From: [Dave Anderson](#)
To: [Robin Proebsting](#)
Cc: anderson9200@comcast.net; "[Gordon Ahalt](#)"; "[Rick Duchaine](#)"; "[Vicki Duchaine](#)"; robertroyalgraham@gmail.com
Subject: RE: MI Treehouse
Date: Thursday, April 8, 2021 9:22:44 PM

Thank you for sharing the updated plans for the proposed residence at 5637 East Mercer Way, submitted by MI Treehouse LLC. It is good to see that the type 2 watercourse is now aligned with the contour lines. Based on the updated site plan, it would appear that the building footprint and deck area have been reduced on the north side of the house to maintain a setback from this corrected stream location. It also appears that the entry on the south side of the house has been eliminated. The finish floor elevations for the garage and main floor have been raised and it would appear that the building footprint has shifted south. The storm water detention facilities have been added with a 48-inch diameter pipe, a type 2 catch basin on the west side and a flow control structure on the east side. It is concerning that the catchment wall that was previously shown on the south side of the structure has been deleted and is not shown on the plan.

**ON-SITE DETENTION SYSTEM**  
NOT TO SCALE (ENGINEER TO FILL IN BLANKS)

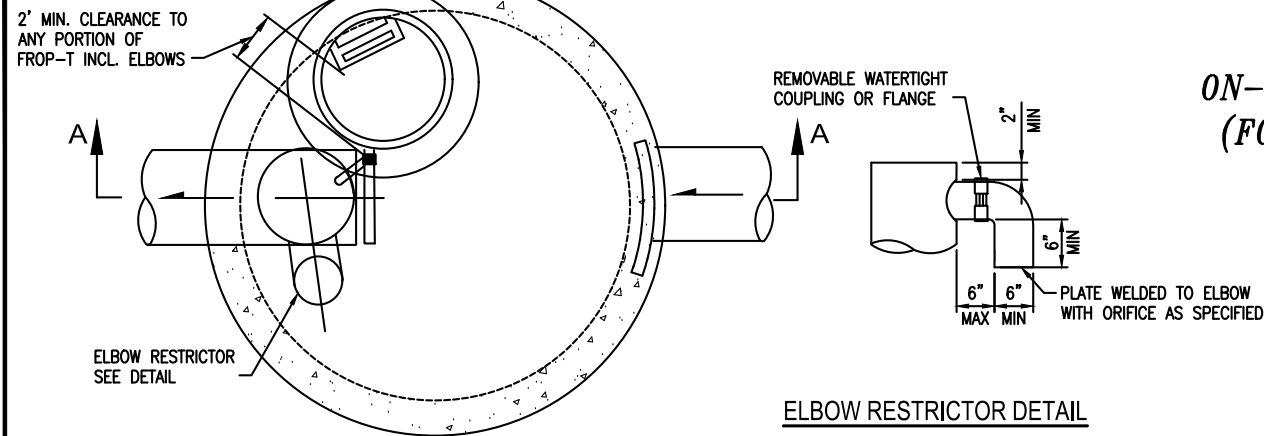
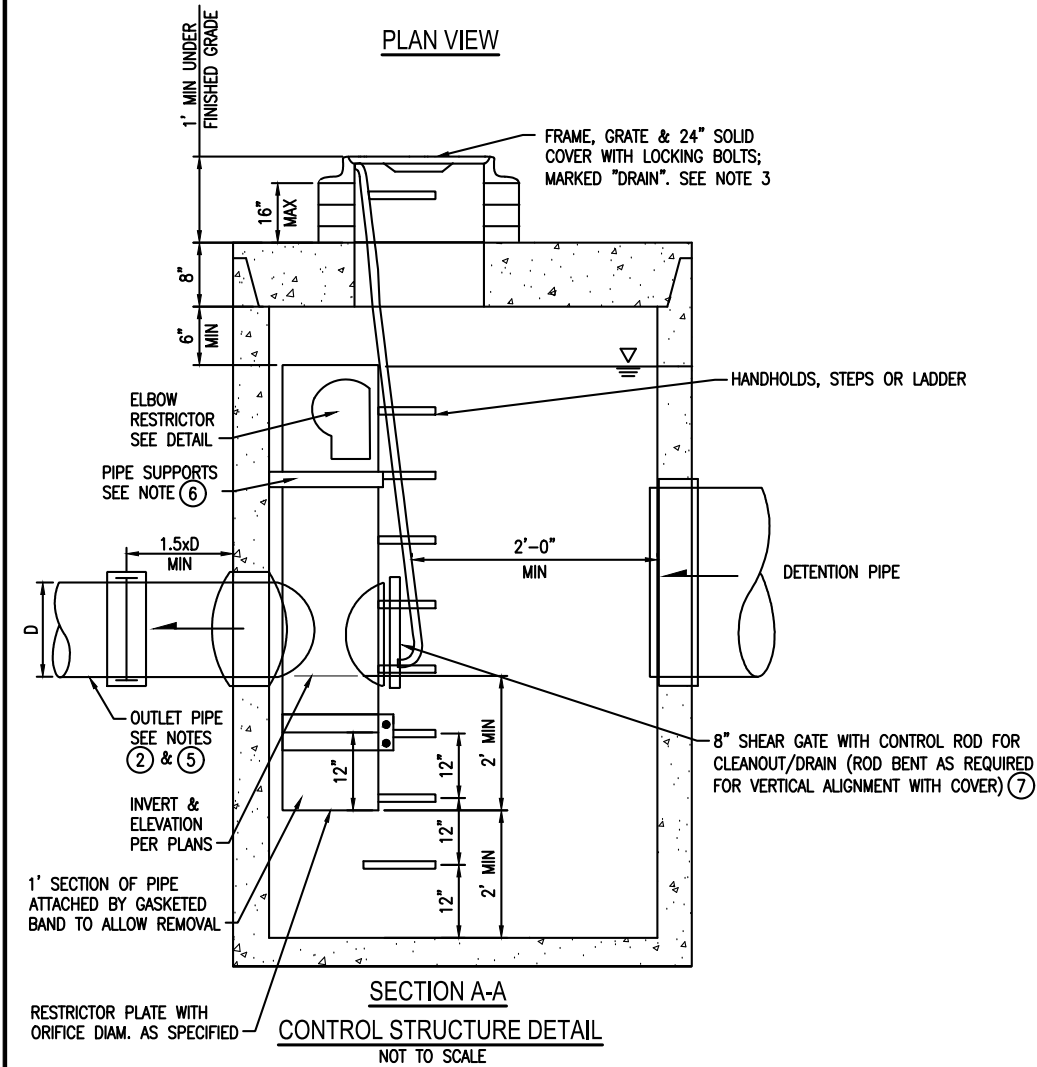
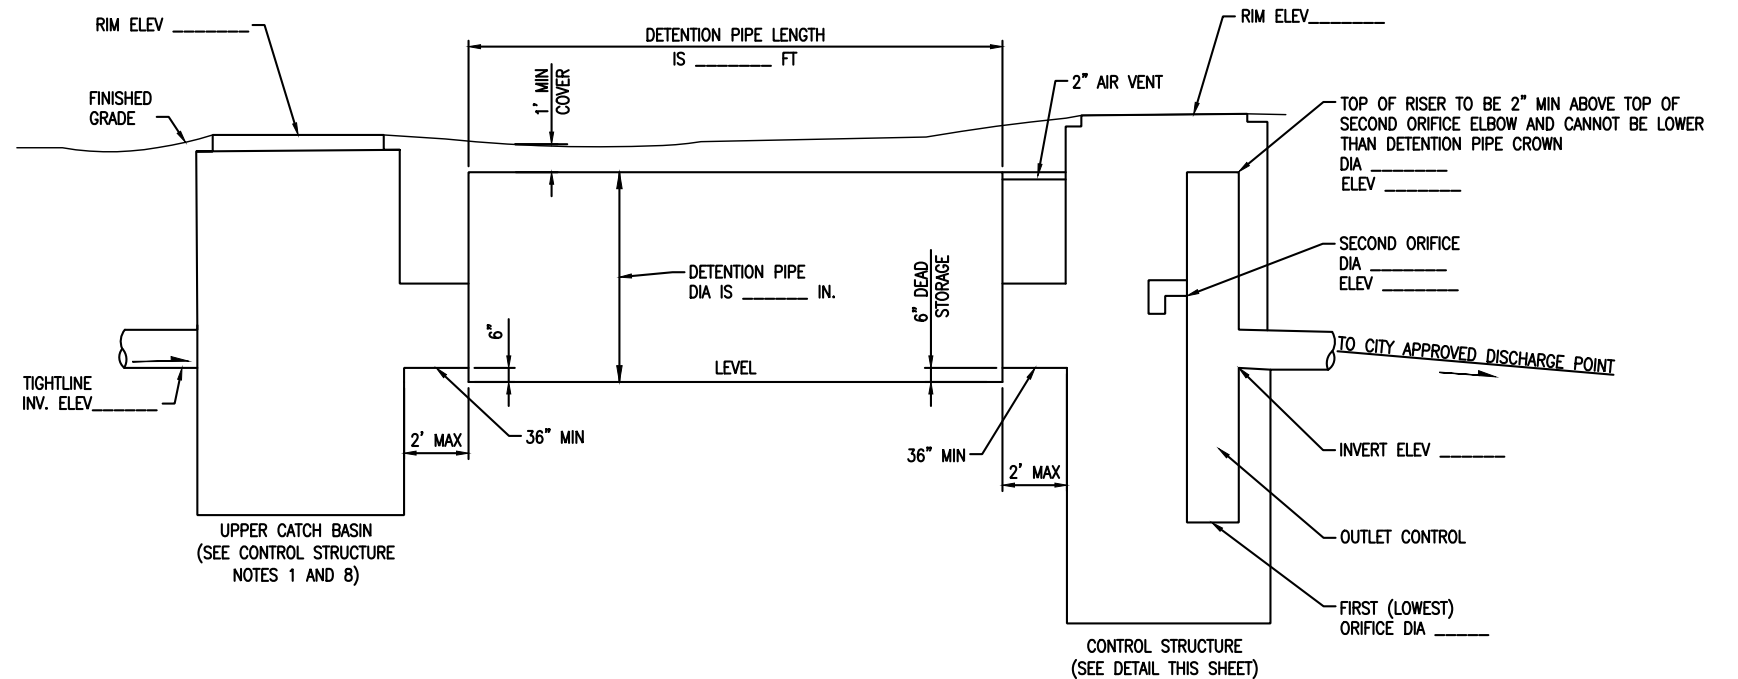
An example of this is the storm water detention pipe and associated drainage structures that have been shown on the plan without any elevations. This type of detention facility requires all of the storage volume to be below the overflow elevation within the restrictor catch basin at the east end of the storage pipe. The storage pipe needs to be installed without slope. The rim elevation for the restrictor catch basin in the driveway will need to be approximately 174. To provide enough clearance for the overflow and the catch basin top with frame and grate, the top of the detention pipe will need to be at least 2 feet below the rim elevation. This would put the invert elevation of the 4' detention pipe at approximately 168. The catch basin at the west end of the pipe will be very close to the entrance to the garage which has a finish floor elevation of 186. The bottom of this catch basin will require an excavation that is at least 2 feet below the detention pipe invert making the structure approximately 20 feet deep. The excavation to install this structure will be 12 feet below the toe of the proposed driveway retaining wall and will extend well below the adjacent stream elevation. Construction of a 20' deep storm structure in a sloping wetland within 15' of a stream will certainly have a much wider impact than what is currently delineated on the plan. Showing a construction impact only 5 feet beyond this wall and so close to such a deep excavation is not accurate or reasonable. Requiring the applicant to comply with the requirements for a complete application including showing the slopes and elevations of the drainage system and the depths and description of the fill materials is critical to properly evaluate and quantify the impacts to the wetlands and adjacent stream.
